RE: DAVID SEVIERI, VOLCANO CLIFFS SUBD UNIT 1 LOT 22 (E-10/D13)
(6312 Montano Rd NW)
ENGINEERS CERTIFICATION FOR CERTIFICATE OF OCCUPANCY
ENGINEERS STAMP DATED 1/29/2001
ENGINEERS CERTIFICATION DATED 11/21/2001

RE: DAVID L. SEVIERI, VOLCANO CLIFFS SUBDIVISION (E10-D13). GRADING AND DRAINAGE PLAN FOR BUILDING PERMIT APPROVAL. ENGINEER'S STAMP DATED JANUARY 29, 2001.

Re: Certification Submittal for Final Building Certificate of Occupancy for
Sevieri Offices, [E10 / D013]
6312 Montano N.W.
Engineer's Stamp Dated 11/21/2001

A PROPOSED GRADING-DRAINAGE PLAN
 FOR
 DAVID L. SEVIERI
 (MONTAÑO ROAD N.W.)
 ALBUQUERQUE, NEW MEXICO
 JANUARY, 2001
 (SEPTEMBER, 2001)

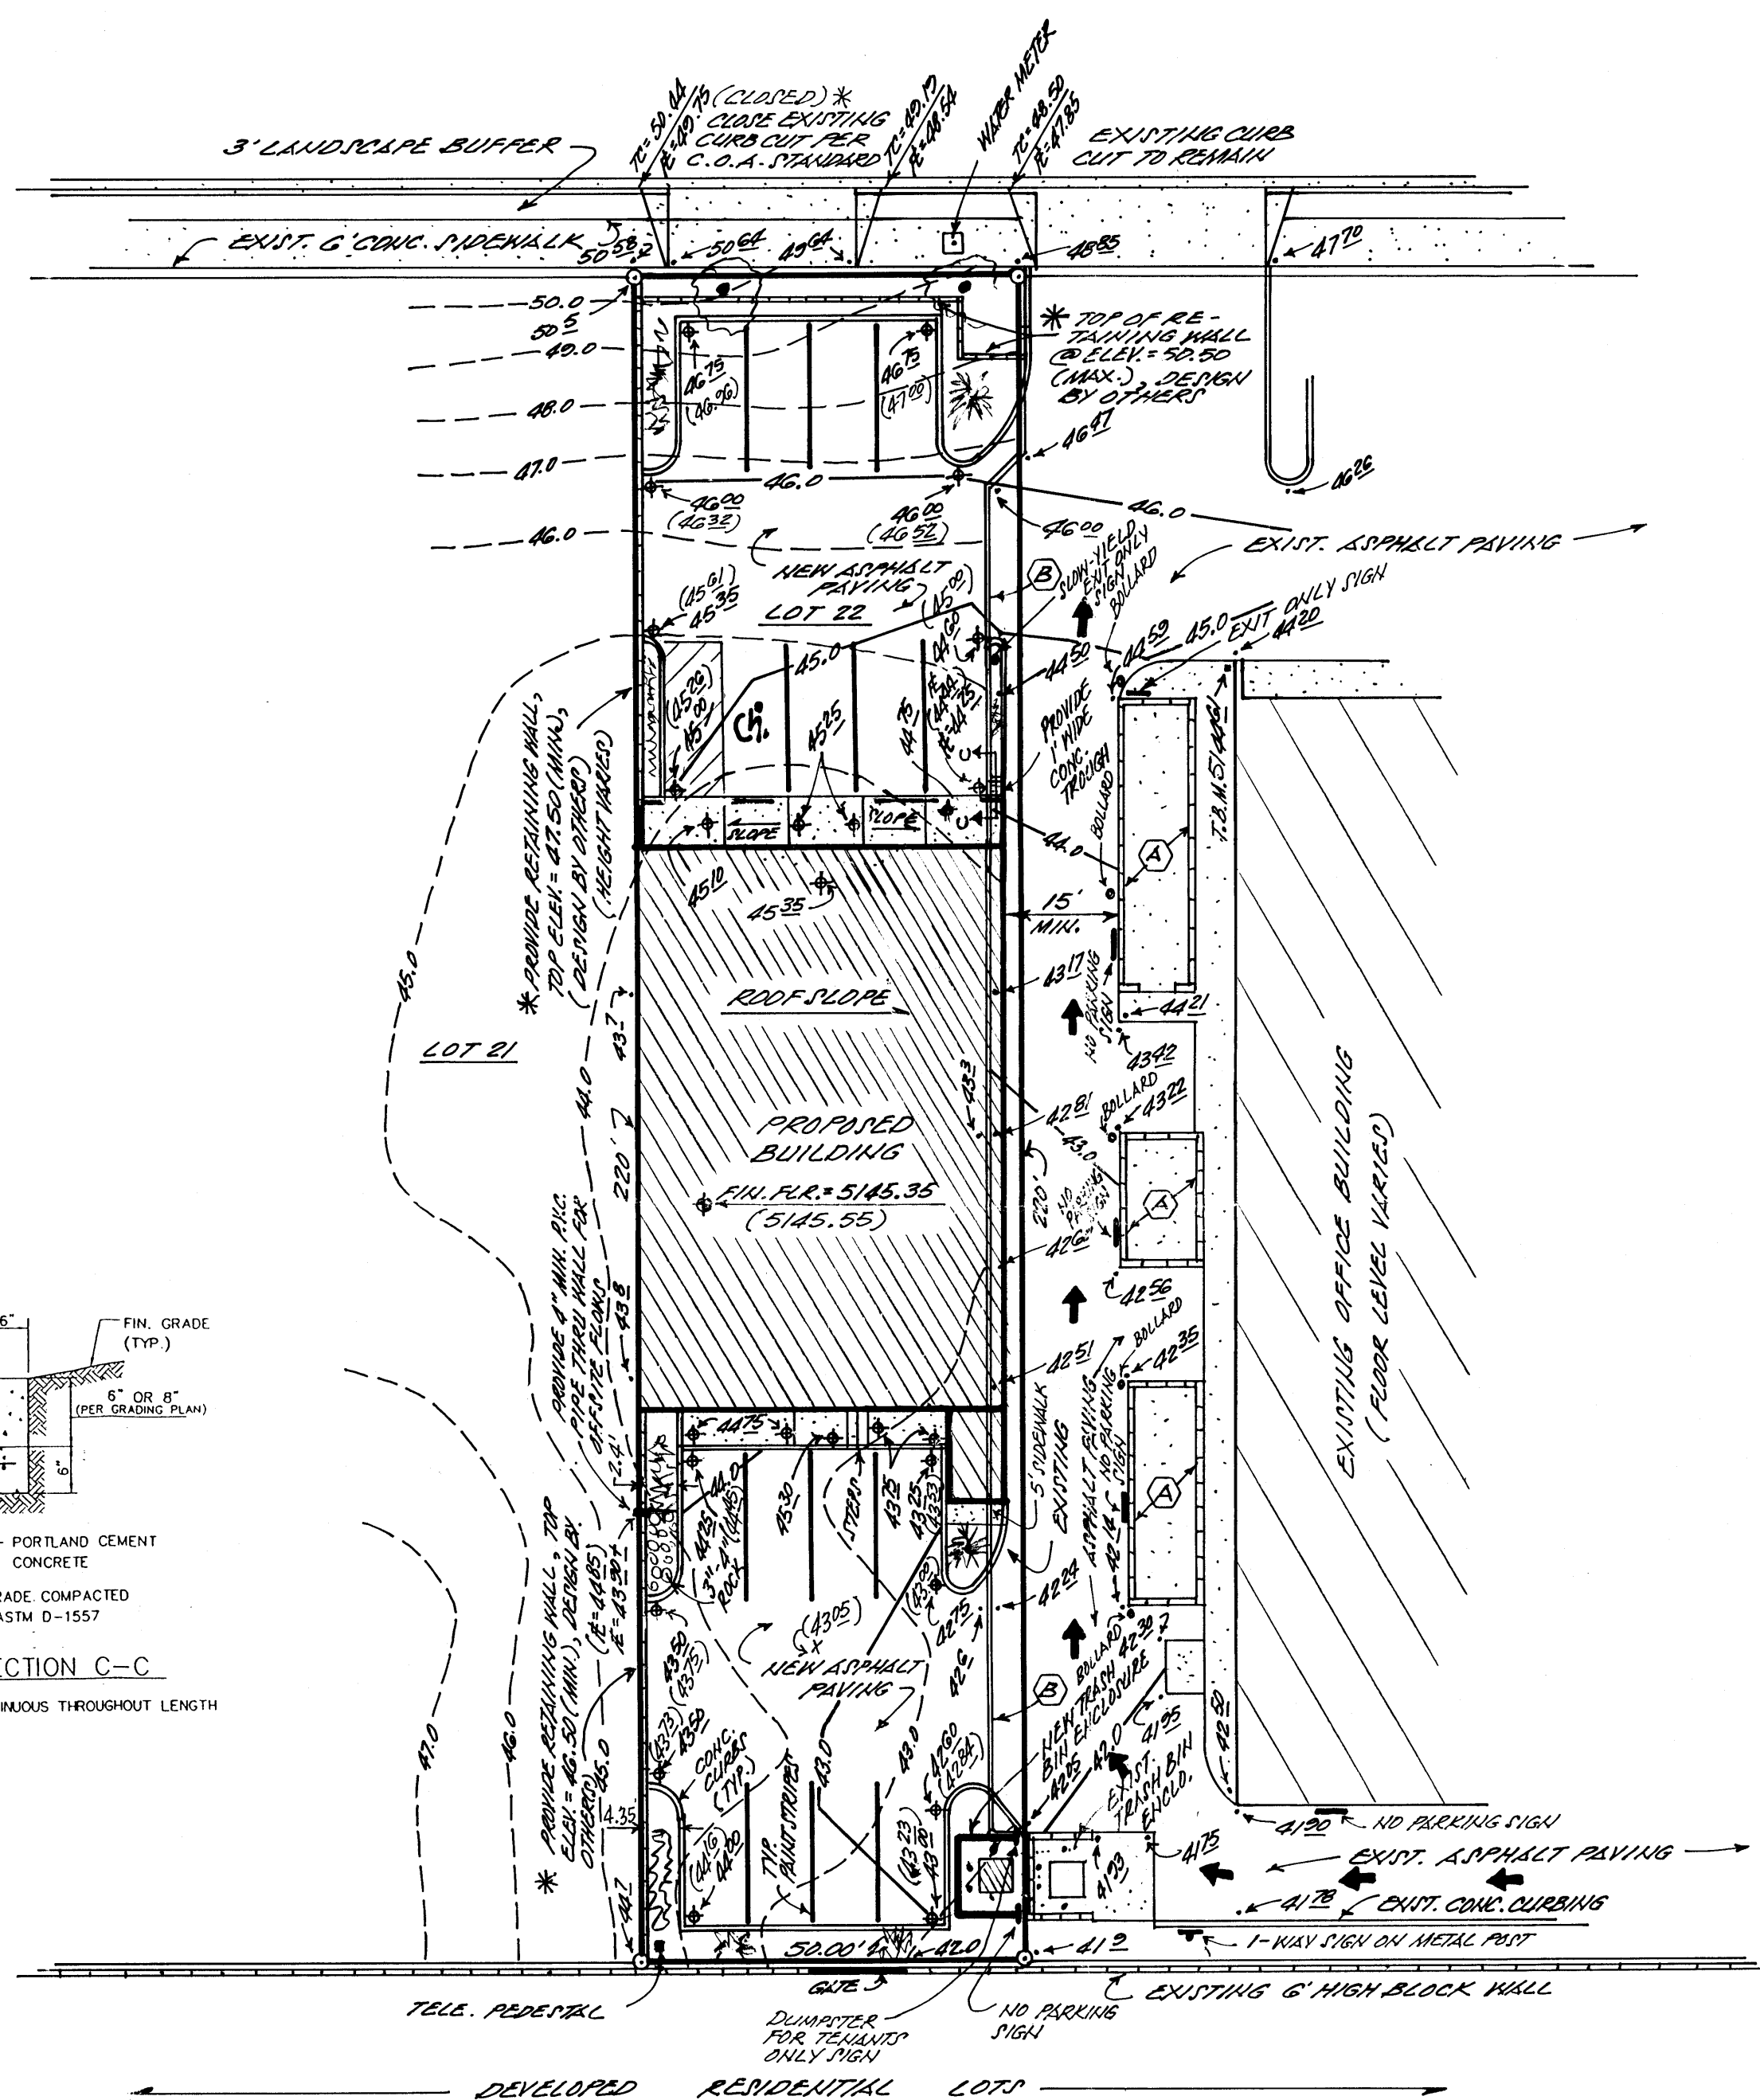
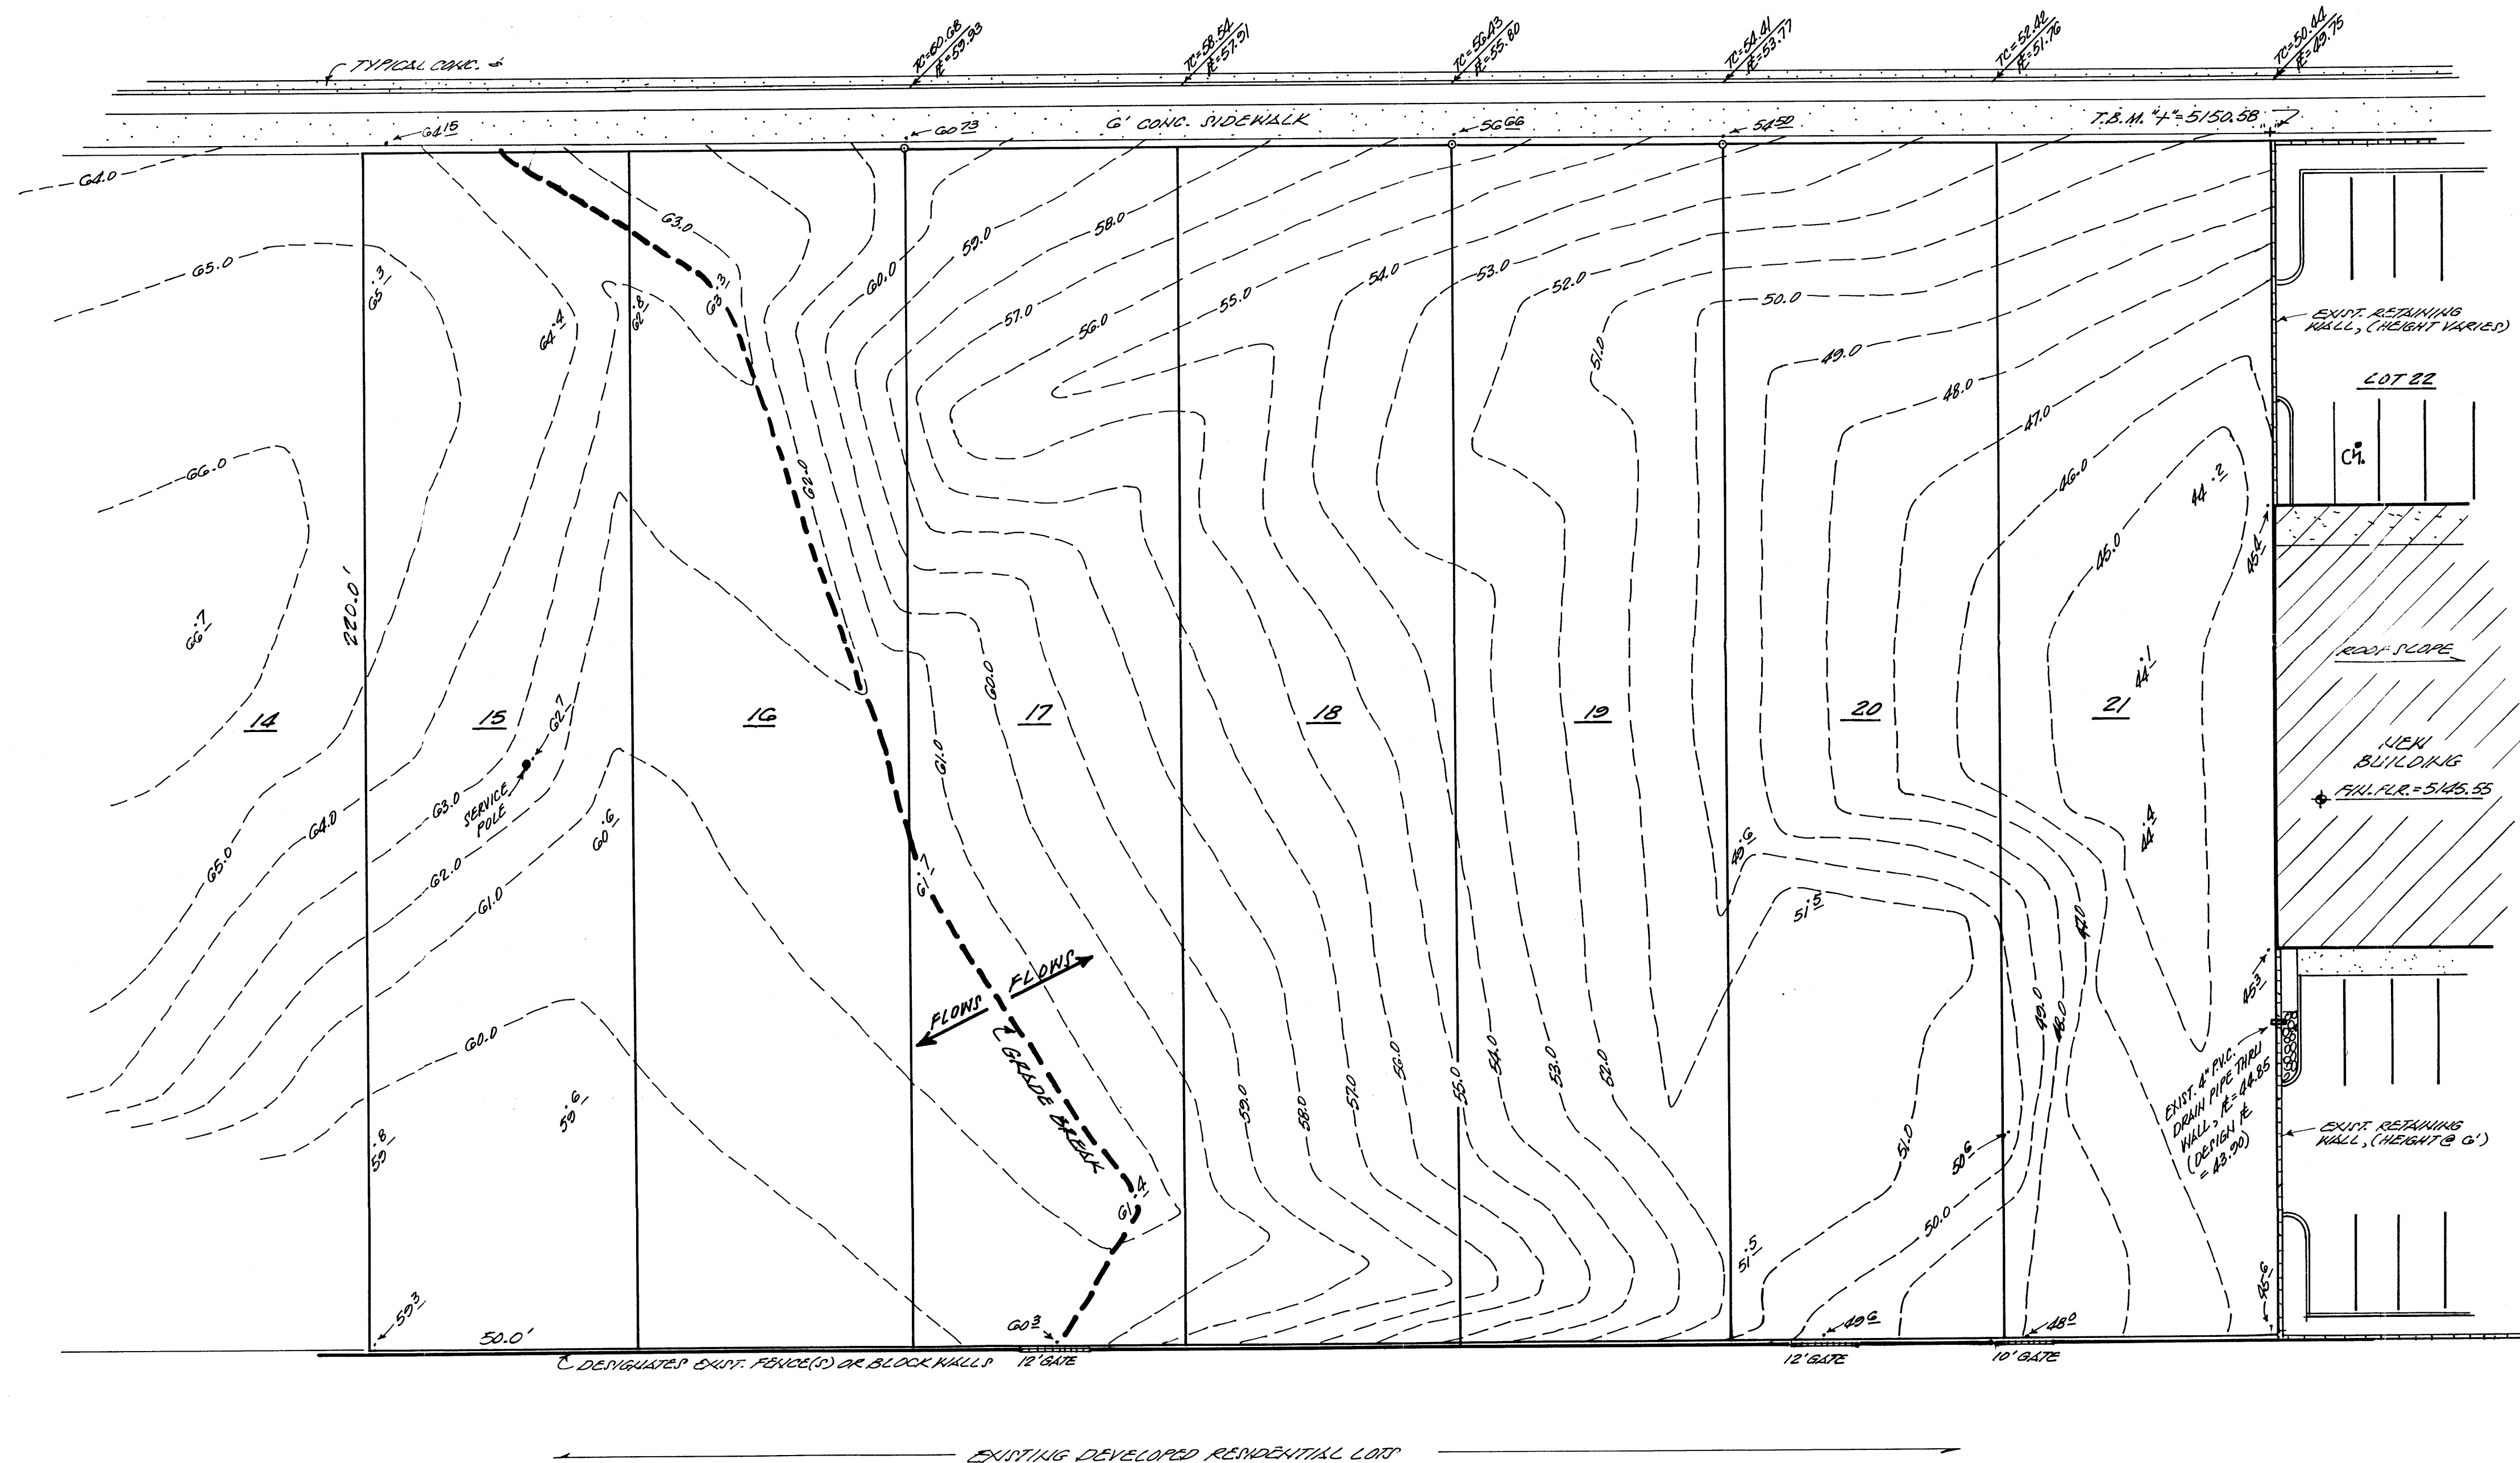
For the Building Permit to be issued, executed copies of the proper access and drainage easements must be on hand! The Q from the property to the west should be stated as should the downstream capacity to the east.

ALSO, the Parties of the "First Part" do hereby grant to the Parties of the "Second Part" an Surface Drainage Easement to convey developed storm surface runoff generated from aforementioned Lot "0-22", (approximately 1.05 cfs) and to temporarily also accept and pass through the historical offsite flows generated by the properties west of and adjacent to aforementioned Lot "0-22" (said historical offsite flows are approximately 1.64 cfs) and at such time of development of said properties developed flows are to be required to be directed into Montano Road N.W. and toward existing storm drainage infrastructure.
